## Rosefield Solar Farm DCO Examination

### Preston Farms Ltd and TCS Biosciences Ltd (PFL/TCS)

#### Submission and evidence following ISH1-2 to inform and assist the Examining Authority – for Deadline 3

DOCUMENT:
ENVIRONMENTAL STATEMENT
VOLUME 3: FIGURES
REGULATION 5(2)(a)

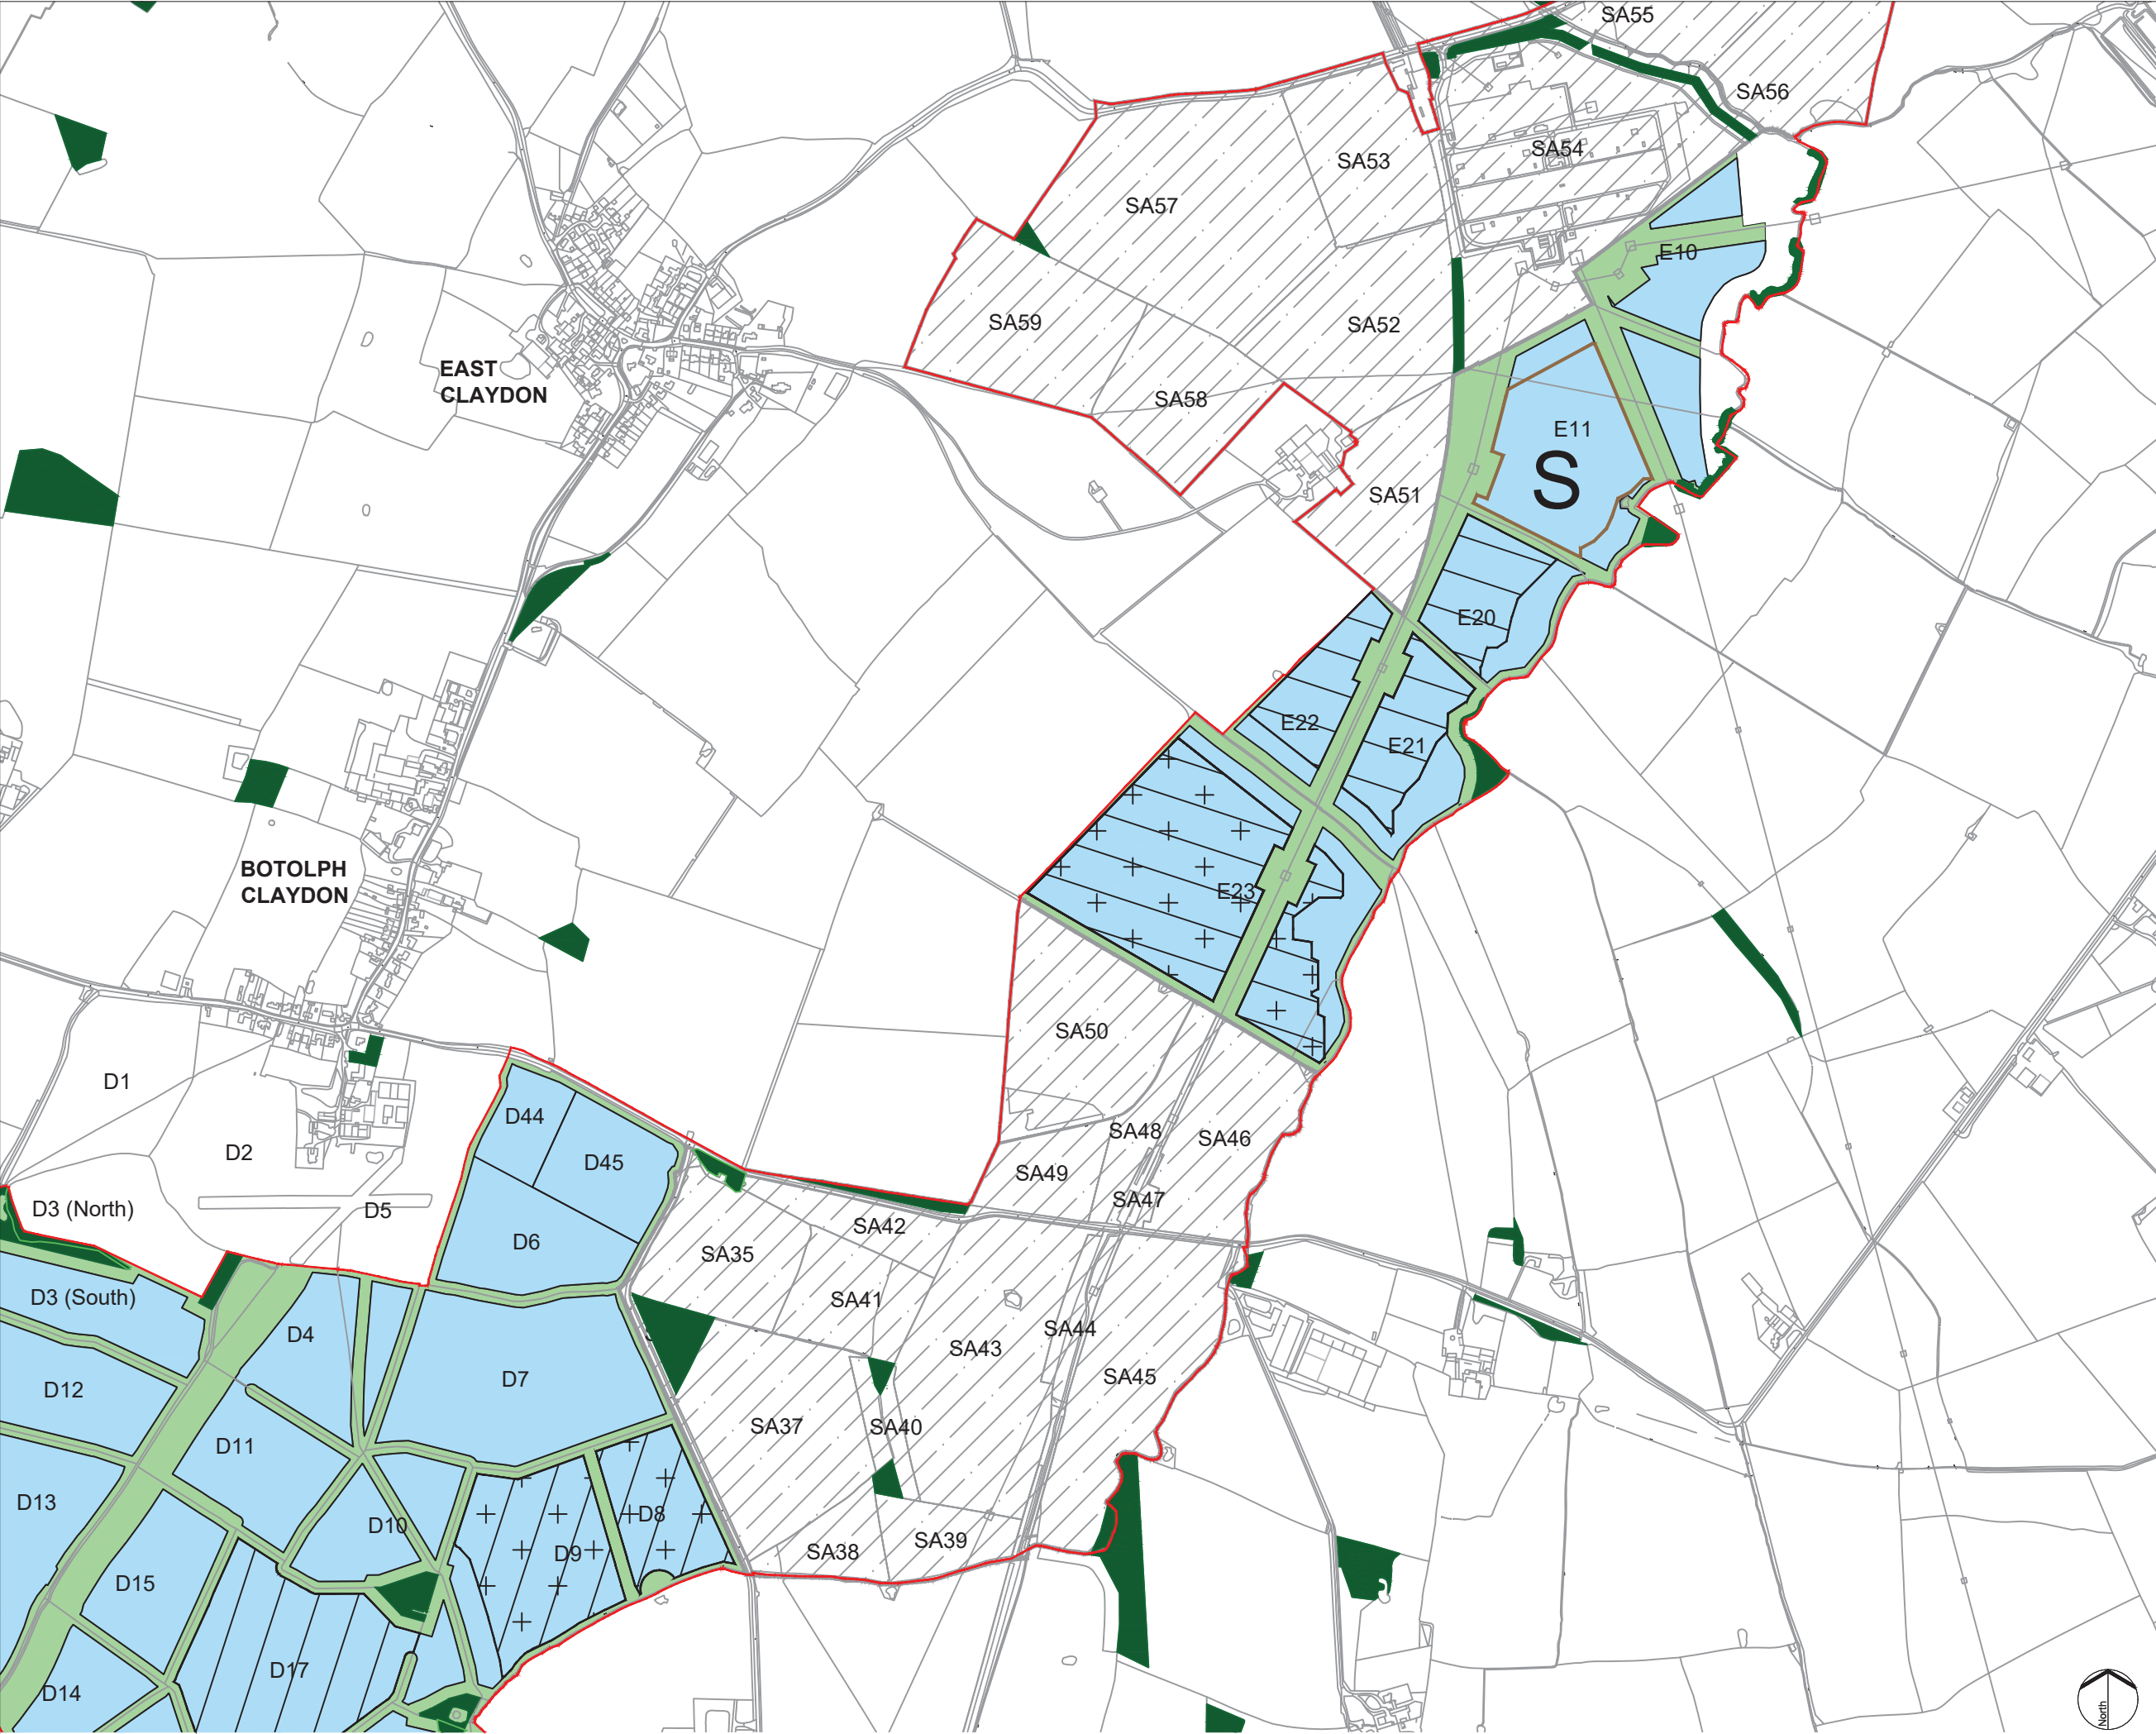
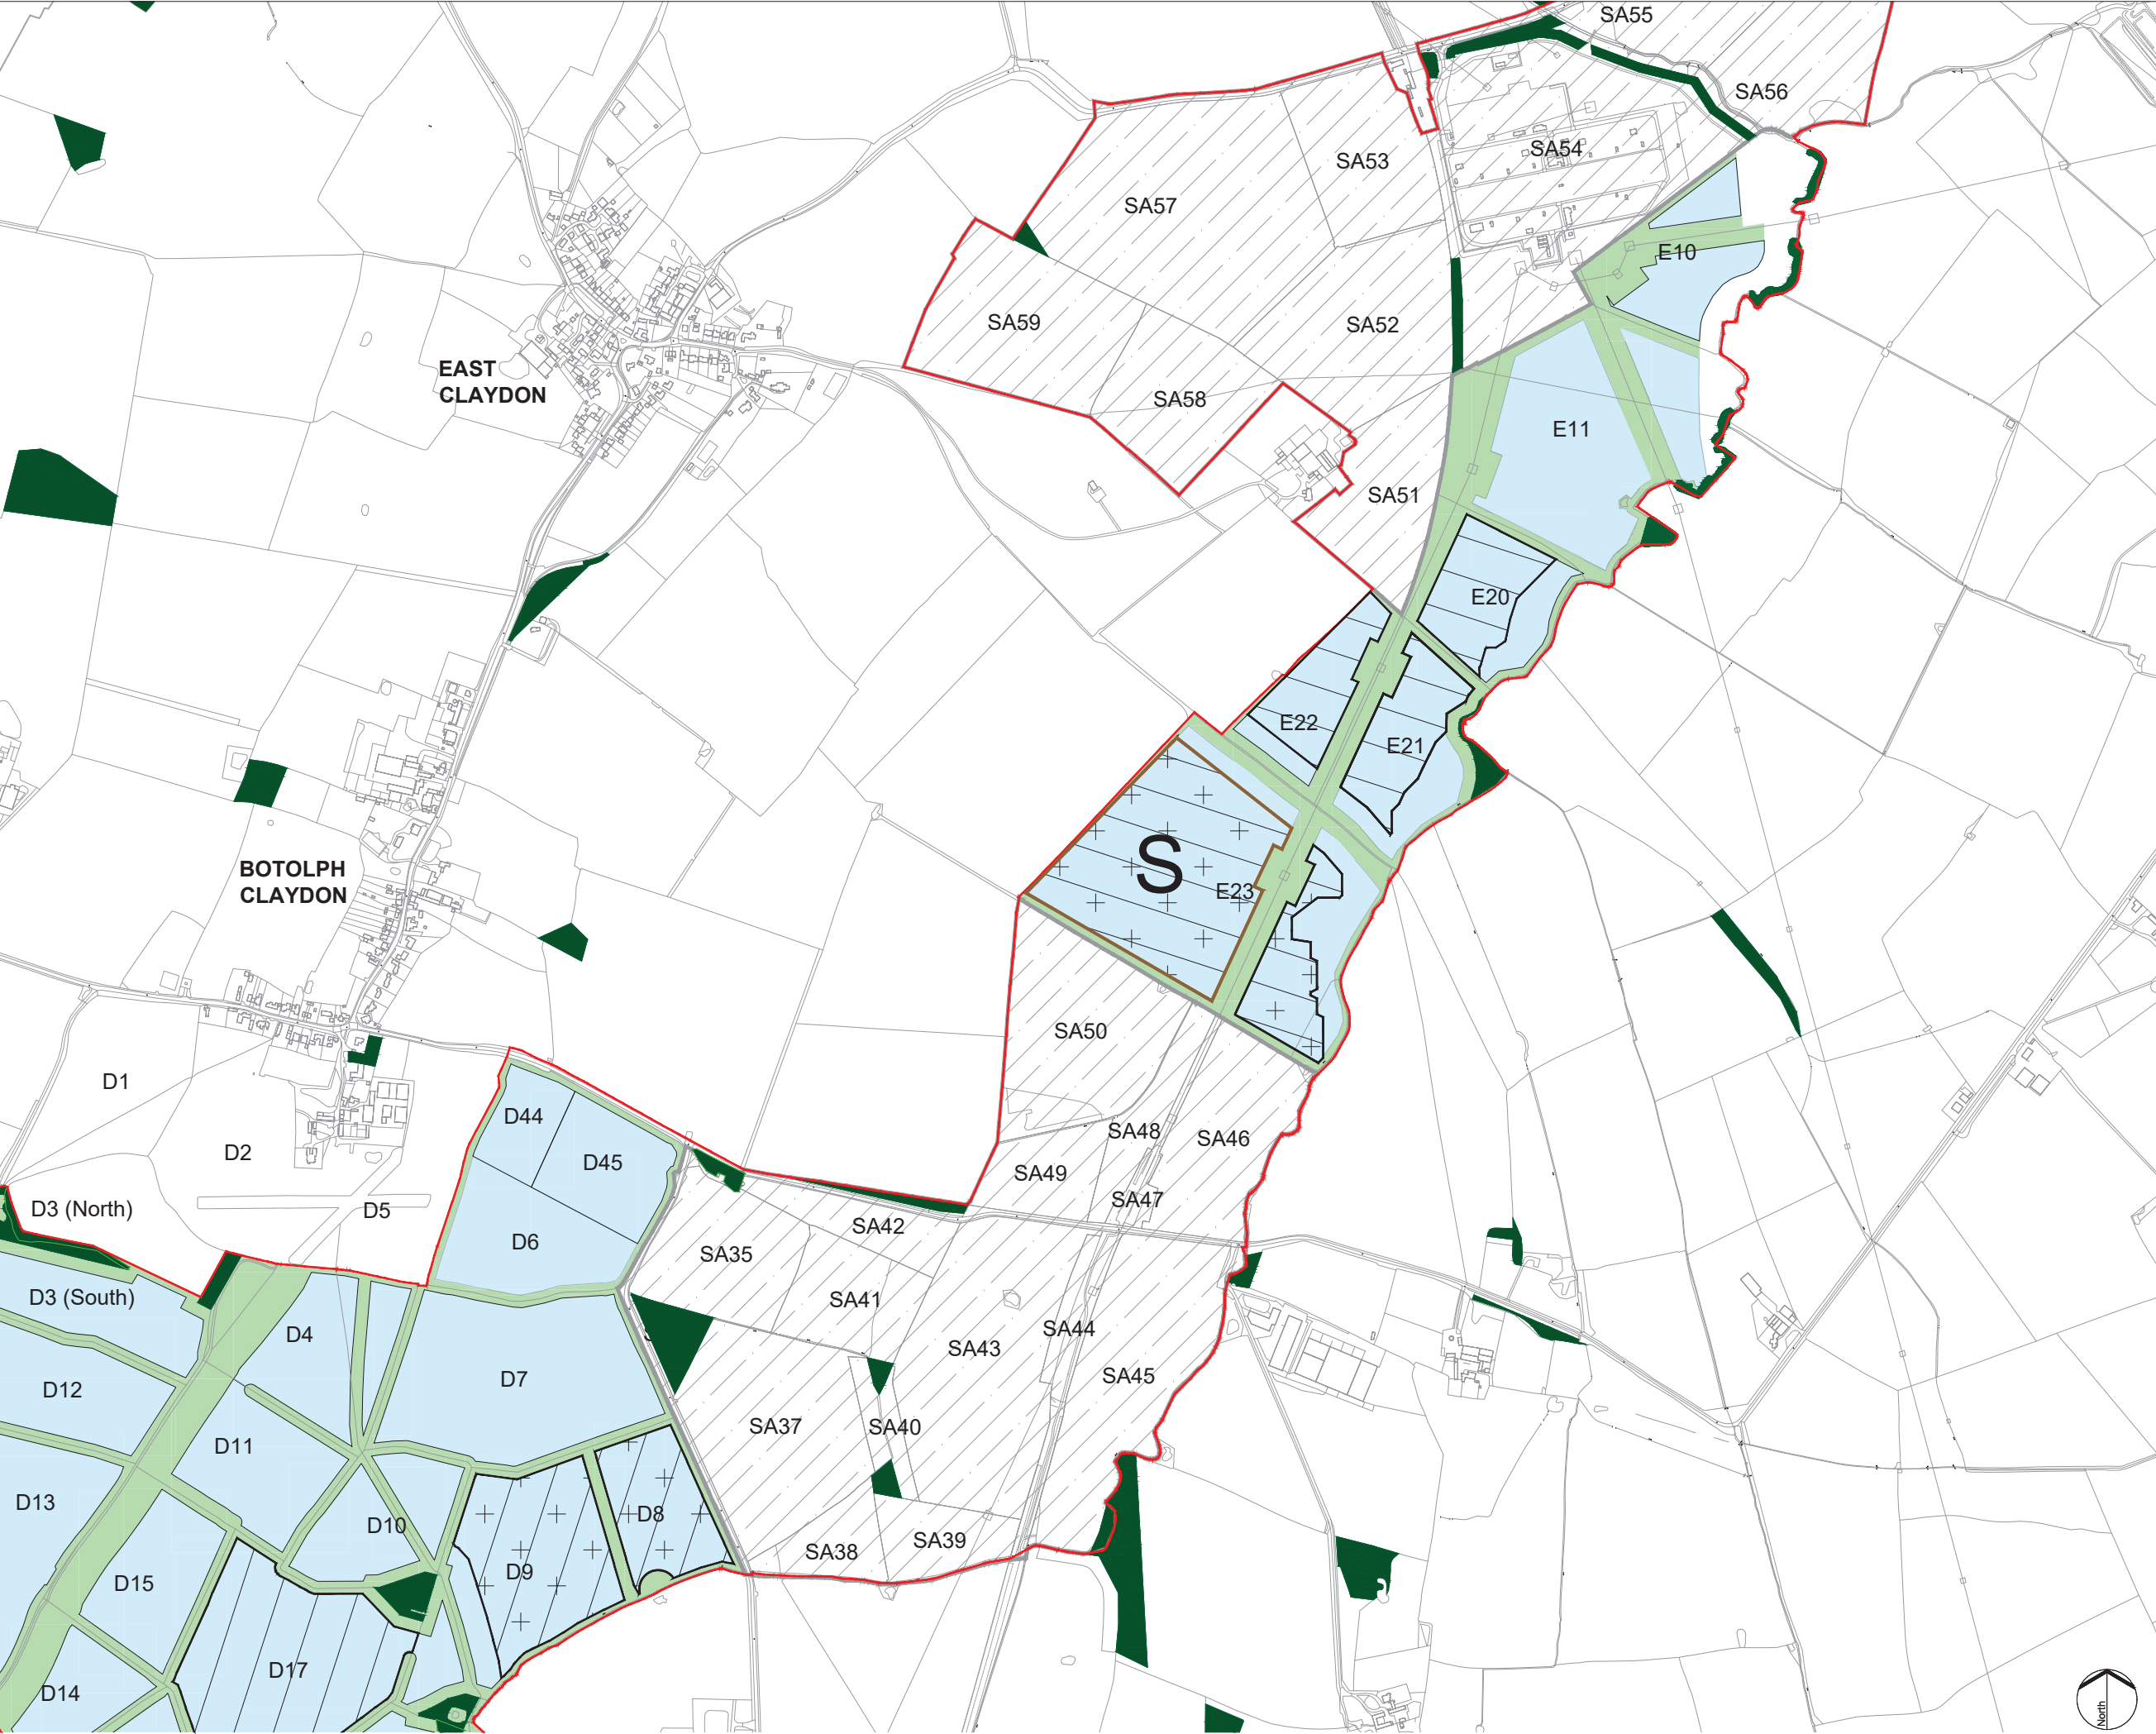
4. Over the lifetime of this project, the Proposals have encroached significantly further into our holding. The Applicant's attempts to assert otherwise are not credible. We know what we were told when we were first approached about the proposals in 2022, and it is shown clearly on the 'site layout' plans in the ES Wintering Birds and Bat Surveys,<sup>1</sup> which stand in contrast to the airbrushing of this part of the history elsewhere in the ES. The shift from a smaller Parcel 3 tightly centred on the East Claydon substation, to the present Proposals Parcel 3 that stretches down to take the heart of our Holding, does not 'mitigate' the impact on us, but the opposite.

5. The fact of the first, subsequently airbrushed, option, shows that there is (a) at least one reasonable alternative the Applicant considered but has not presented or explained in the ES for the purposes of the EIA Regulations; (b) at least one alternative to be considered when applying compulsory acquisition principles (see our WR, but in short part of the 'compelling case' is an absence of alternatives);<sup>2</sup> and (c) there is a

<sup>1</sup> **APP-089** pp27-28 (Figures 1 and 2, including 'site location' red line plans), see also **APP-088** pp18, 21 (Figure 1, Figure 2.3, including 'site location' red line plans). Then see **APP-047** (reasonable alternatives considered), in particular section 4.7, for the complete lack of acknowledgement of this within the purported explanation of the design evolution.

<sup>6</sup> See **APP-088** (2022 bat survey) and **APP-089** (2022 wintering birds survey) and in particular their figures which show the originally proposed site red line and demonstrate the limited extent of 'parcel 3' as first explained to us. Then see **APP-047** (reasonable alternatives considered), in particular section 4.7, for the complete lack of acknowledgement of this within the purported explanation of the design evolution.
